From: [Borough Planning](#)  
To: [REDACTED]  
Subject: RE: Planning documents, The Lavenders, 23/00271/F  
Date: 27 February 2023 11:41:33  
Attachments: image008.png  
image009.png  
image010.png  
image011.png

Planning 23/00271/F Sandra Homcenko  
The Lavenders  
St Andrews Lane  
Congham  
PE32 1DU

The Lavenders, St Andrews Lane, Congham, Norfolk, PE32 1DU

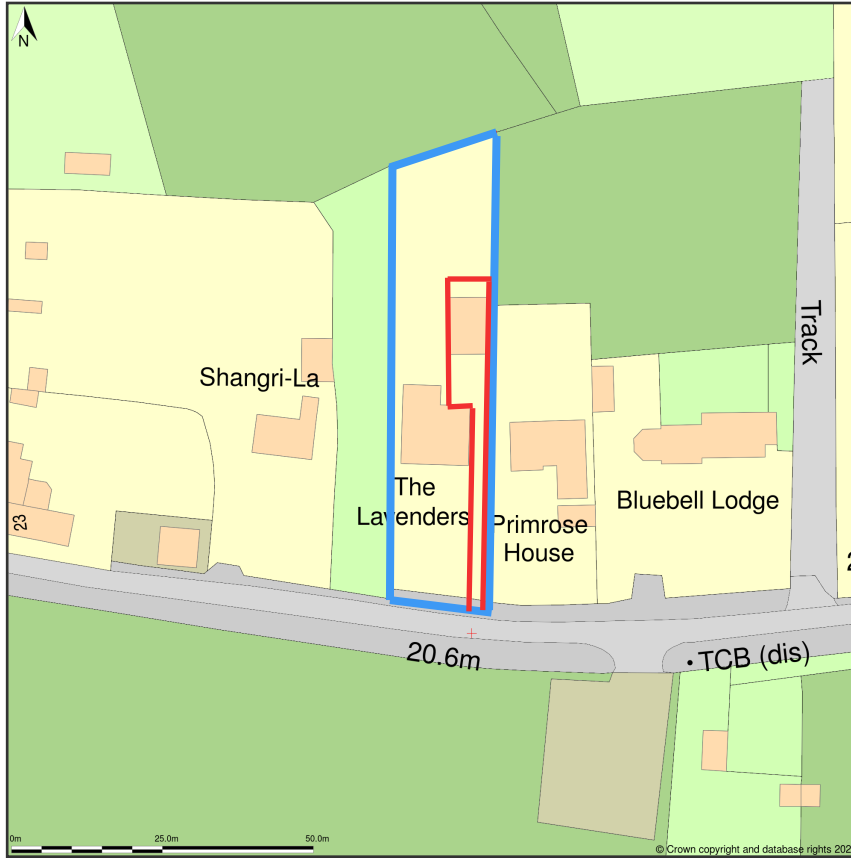
Unfortunately, the red line includes the whole residential boundary, if this application is for change the use of the entire site it will be acceptable. If only the annexe is to be used for the lets the red line should be edged around the area affected by the proposal only.

The red line should include the access to the let and the allocated curtilage for your customers , red line on both - location plan and block plan should be scalable and identical, please correct and resend.
